Colston Budd Rogers & Kafes Pty Ltd

9 November, 2017

**RE: S75W APPLICATION FOR EASTLAKES SHOPPING CENTRE
NORTHERN SITE DEVELOPMENT**

title
SECTION 75W APPLICATION
 Basement 3

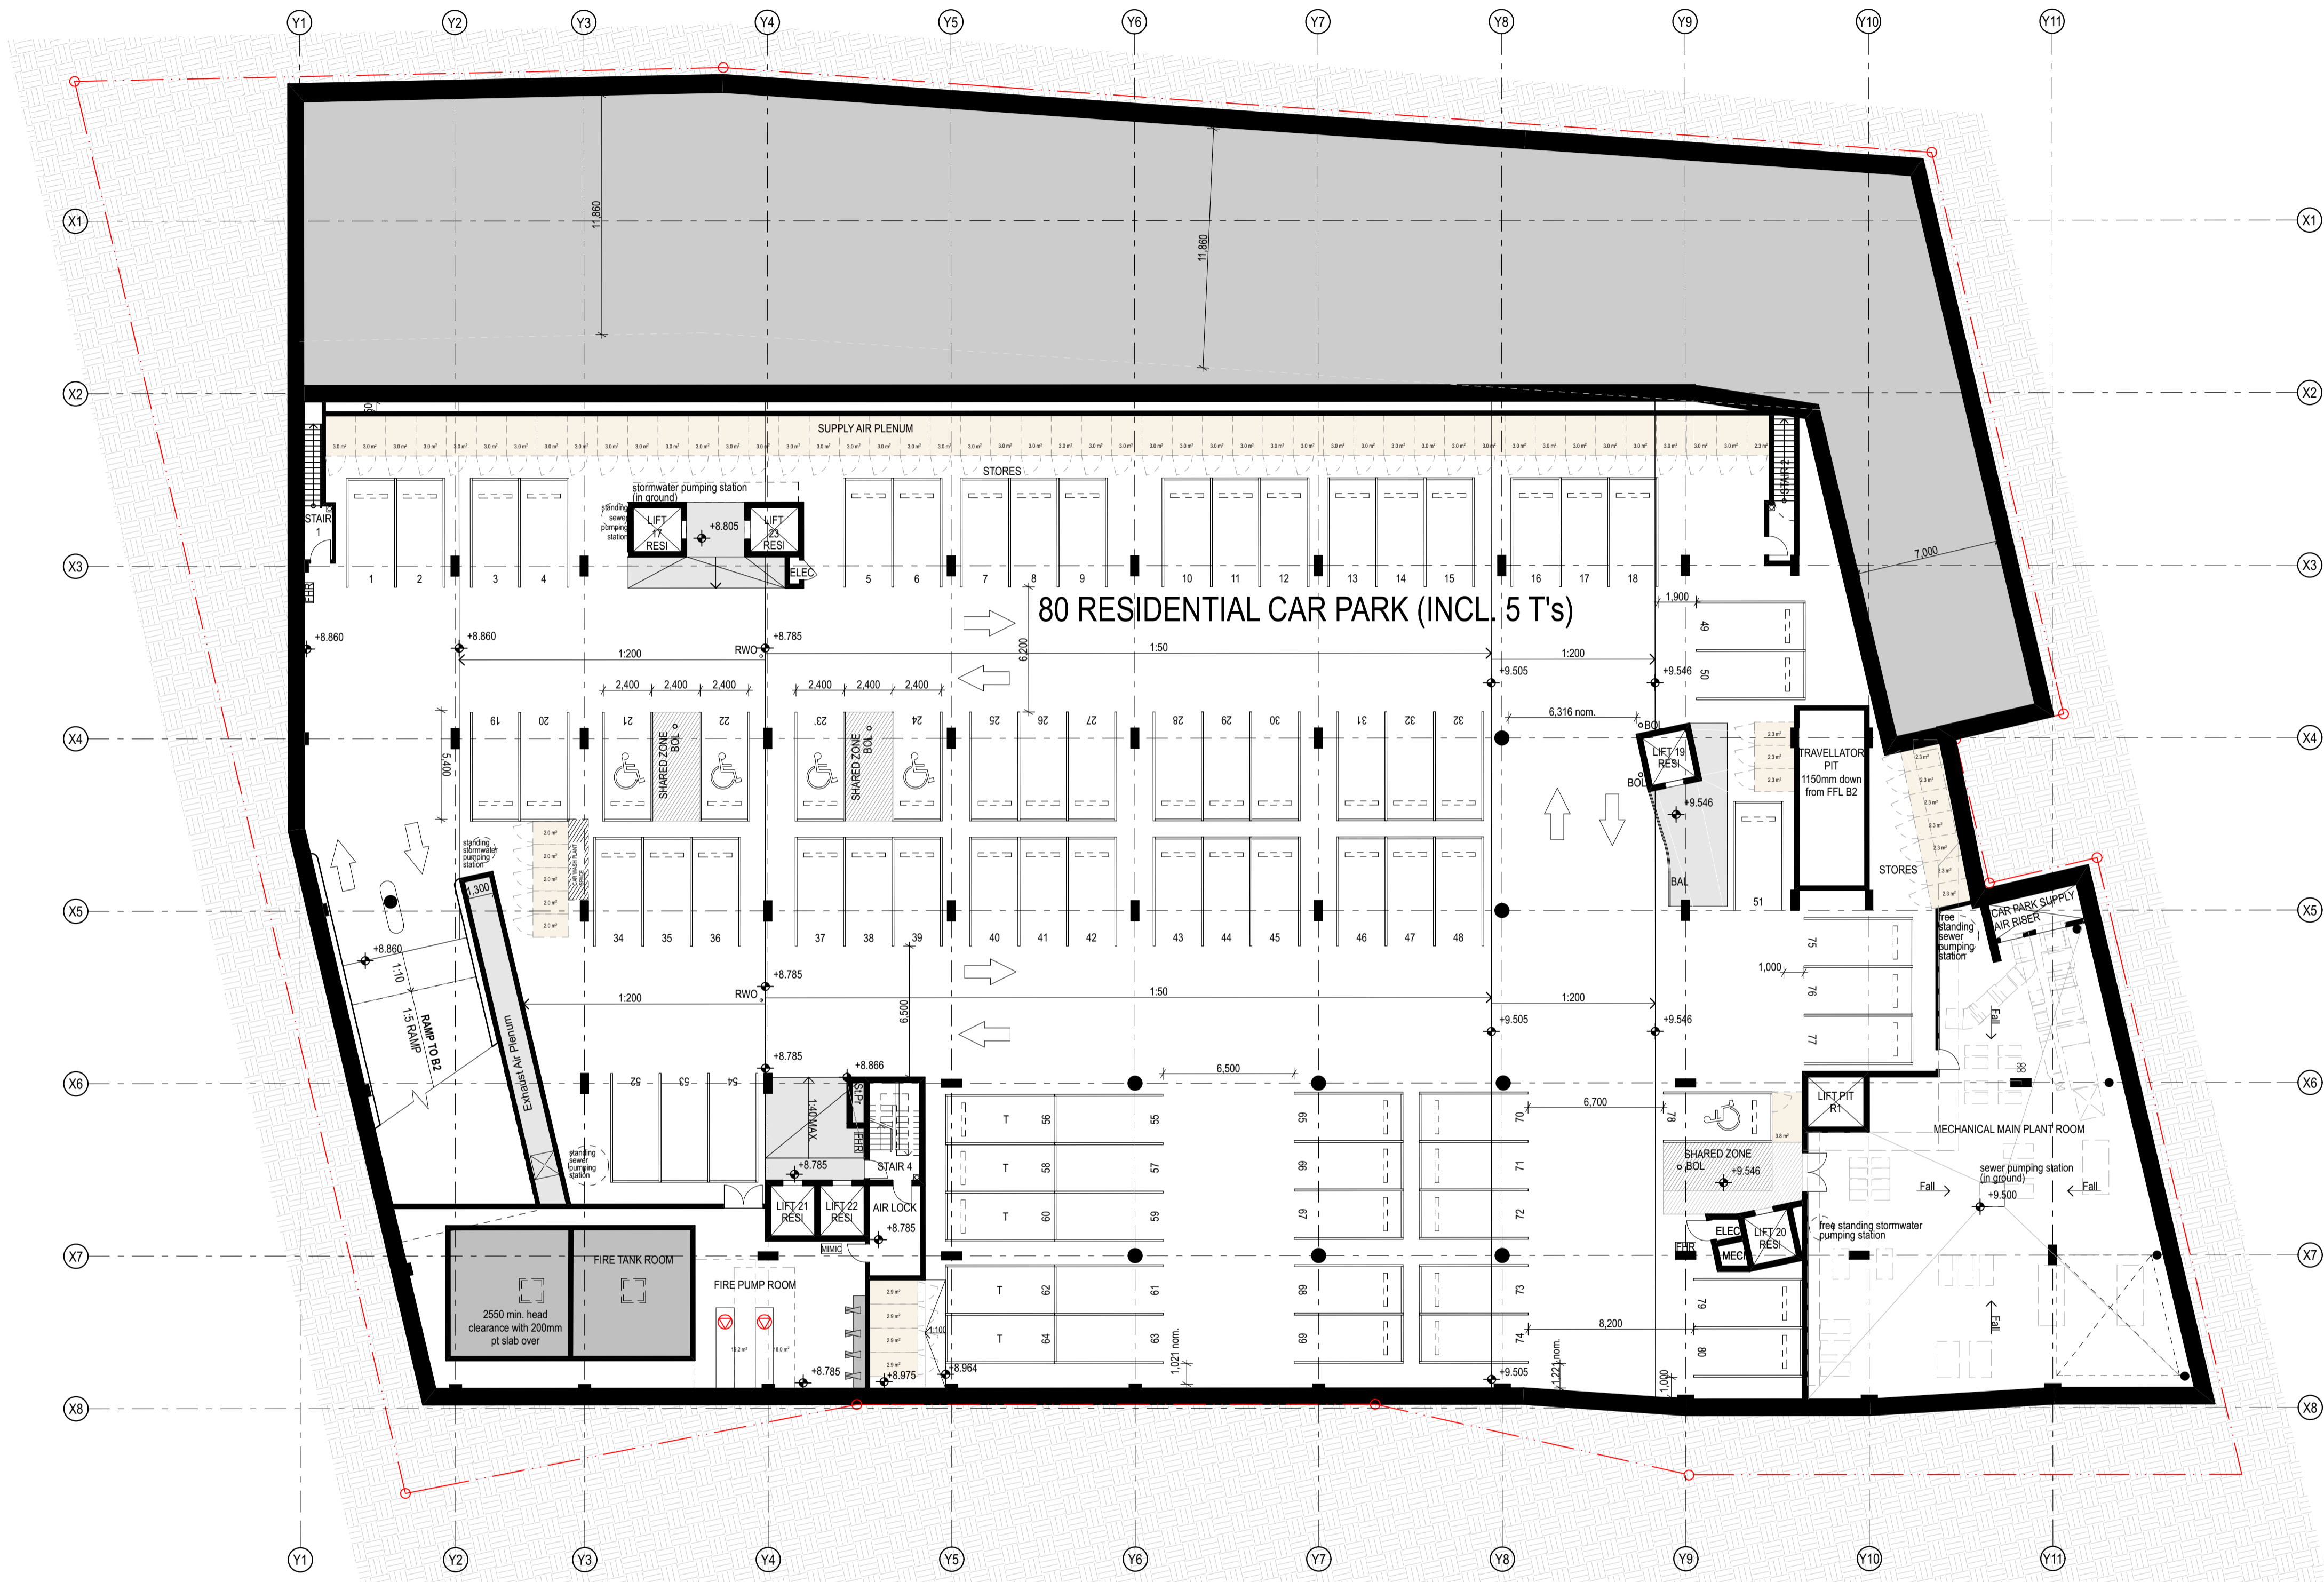
5. Council also noted that some of the parking for the northern site development is proposed to be provided in the southern site. It is now proposed to provide all the parking for the northern site development on the same site, by provision of a third basement level.

7. Application of the approved parking rates results in a requirement for 272 parking spaces. The proposed northern site development, including the third basement parking level, will provide parking for 280 vehicles (136 retail and visitor parking spaces and 144 residential parking spaces) satisfying this requirement.

8. Retail parking will be provided on levels B1 and B2 with residential parking on levels B2 and B3. Busy times for residential visitor parking and retail parking will occur at different times. Therefore, to make efficient use of the parking provision, the residential visitor parking would be shared with the retail parking.
